Lower Thames Crossing

5.4.4.13 Final Agreed Statement of Common Ground between (1) National Highways and (2) Tonbridge & Malling Borough Council (Clean version)

DATE: December 2023
DEADLINE: 9A

Planning Inspectorate Scheme Ref: TR010032
Application Document Ref: TR010032/APP/5.4.4.13

**Figure 7-1 A228 corridor between M2 and M20**

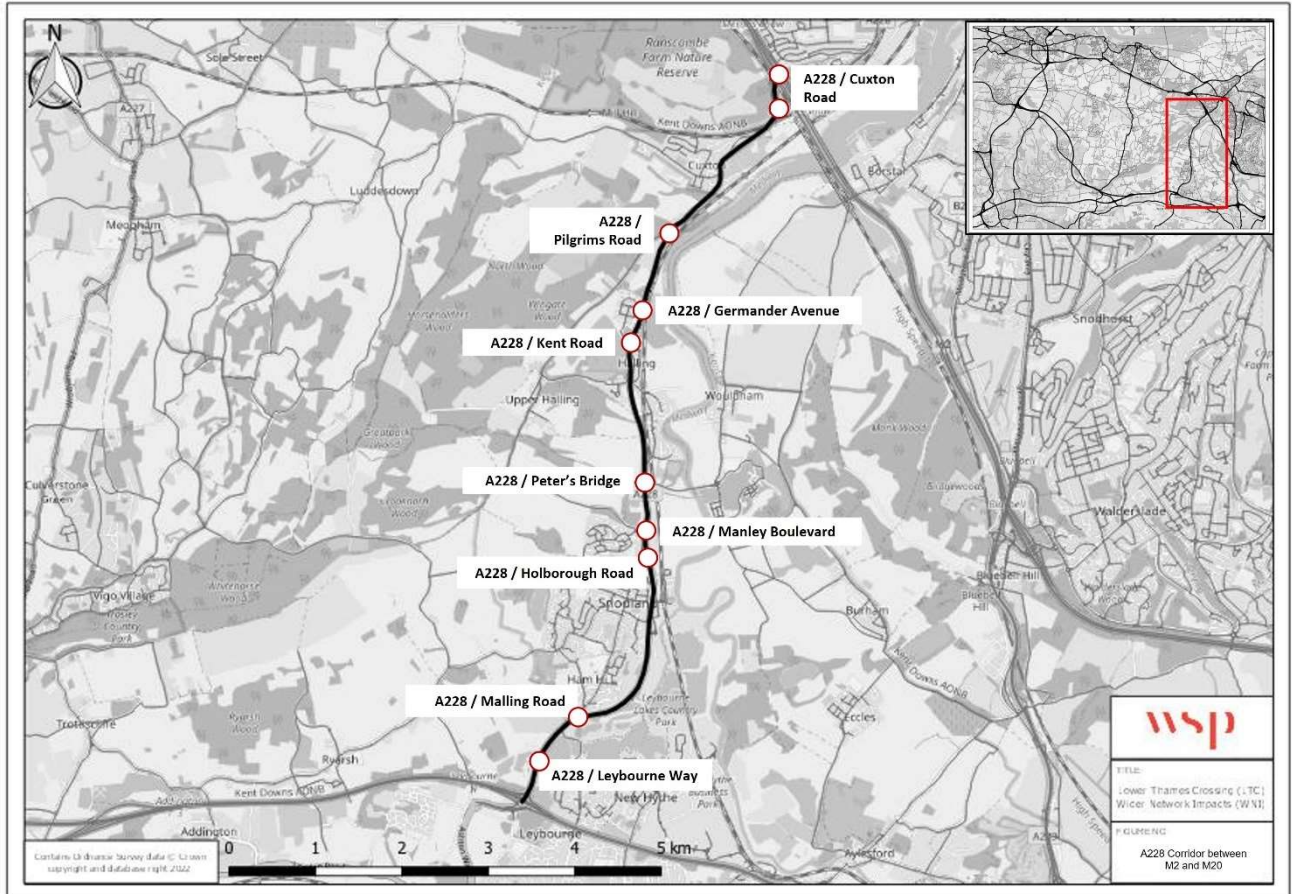
Wider Network Impacts					
<p>Local WNI Concerns</p> <p>A228 corridor between M2 Junction 2 and M20 Junction 4</p>	<p>2.1.9</p> <p>RRE</p>	<p>TMBC has concerns regarding the A228 corridor between M2 Junction 2 and M20 Junction 4. Mitigation is required as set out in KCC's D7 submission [REP7-198], for which no funding is currently committed or otherwise available locally. KCC's (WNI study) identifies the following requirements for the A227 and A228 corridors:</p> <ul style="list-style-type: none"> Reduction of the speed limits across the A227, A228 and other minor roads across the corridor. 	<p>The Applicant has worked with Kent County Council (KCC) on a Kent Wider Network Impact (WNI) study, funded by the Applicant, which aimed to further joint understanding of how the network would perform in the future with the Project. These outputs were discussed with KCC and TMBC, and the Applicant will continue to engage in accordance with the licence obligations to work with others to align national and local plans and investments, balance national and local needs and support better end-to-end journeys for road users. This will include working</p>	<p>Wider Network Impacts Management and Monitoring Plan</p> <p>[Document Reference 7.12 (2)]</p> <p>Responses to the Examining Authority's ExQ1 Appendix B –</p>	<p>Matter Not Agreed</p>

Topic	Item No.	Tonbridge & Malling Borough Council Comment	The Applicant’s Response	Application Document Reference	Status
		<p>Further detail is set out in our Local Impact Report. Mitigation will be required to improve this route and its junctions,.</p> <p>Given the extent of the impacts on roads locally, it is TMBC’s opinion that the Project should be complemented by other highways investment that addresses these impacts.</p>	<p>Hill is included as a monitoring location in the WNIMMP.</p> <p>The DCO requires the Applicant to produce an operational traffic monitoring scheme that complies with this plan prior to the tunnel opening, and on which local highway authorities will be consulted.</p>		
<p>Non-Project highway improvements</p> <p>A2/M2 corridor</p>	2.1.13	<p>TMBC shares the view of Kent County Council that to realise the full benefits of the Project, it is essential that the A2/M2 corridor to which it connects is looked at holistically. Improvement schemes identified as pipeline projects for the next Road Investment Strategy at 'A2 Brenley Corner' and 'A2 Access to Dover' need to be delivered alongside other capacity enhancements along the M2 and improved connections to the M20 to ensure that the two strategic corridors to the Port of Dover and Channel Tunnel are resilient. These projects remain unfunded.</p>	<p>The Applicant is bringing forward the A122 Lower Thames Crossing in accordance with the policy requirements set out by the Government in the Road Investment Strategy 2: 2020 – 2025 (Department for Transport, March 2020). This sets out a series of further projects to be delivered under separate consenting and funding decision processes to the A122 Lower Thames Crossing. While the Applicant recognises the case for developing further schemes to improve operations along the M2/A2 and M20/A20 corridors, the A122 Lower Thames Crossing does not require the emerging improvements to deliver the benefits set out in the A122 Lower Thames Crossing application. Similarly, the case for these schemes is not dependent on the opening of the A122 Lower Thames Crossing.</p>	<p>Wider Network Impacts Management and Monitoring Plan [Document Reference 7.12 (2)]</p>	<p>Matter Not Agreed</p>

Topic	Item No.	Tonbridge & Malling Borough Council Comment	The Applicant's Response	Application Document Reference	Status
		piecemeal, protracted and could put at risk the delivery of other planning obligations e.g., affordable housing.	previously stated. The proposed interventions are not required to achieve the benefits of the LTC and are not necessary to address safety or severance issues arising from the project.		
Non-Project highway improvements Request for commitment to provide additional highway improvements on the A229 at Blue Bell Hill	2.1.10 RRE	<p>The Council is concerned about the impact of the Project upon the A229 at Blue Bell Hill which connects M2 Junction 3 with M20 Junction 6, this is a high priority for improvement. The road and its motorway junctions need to be improved to accommodate the in combination impacts of LTC and Local Plan growth related traffic. Further detail is set out in our Local Impact Report.</p> <p>Given the extent of the impact on roads locally, it is TMBC's opinion that the Project should be complemented by other highways investment that addresses these impacts. Blue Bell Hill is the subject of a Large Local Majors scheme bid to the Department of Transport, for which the strategic outline business case has recently been approved.</p> <p>The new crossing will have implications on the M2 Junction 3, the A229 Blue Bell Hill and M20 Junction 4 within the Borough.</p>	<p>Improvements to the A229 and the M2 east of Junction 1 are not part of the proposed Project.</p> <p>The Applicant will continue to engage with relevant authorities in accordance with the licence obligations and work with others to align national and Local Plans and investments, balance national and local needs, and support better end-to-end journeys for road users.</p> <p>The Wider Network Impacts Management and Monitoring Plan (WNIMMP) has been submitted as part of the application and sets out the proposed approach for the monitoring of traffic impacts for the Project during its operational phase, to identify changes in the performance on the surrounding local, major and strategic road networks. The monitoring data would be made available to all the local and highway authorities, which would be able to use this as evidence to support scheme development and case making through existing funding mechanisms and processes. The M2 Junction 3 at Blue Bell</p>	Wider Network Impacts Management and Monitoring Plan [Document Reference 7.12 (2)]	Matter Not Agreed
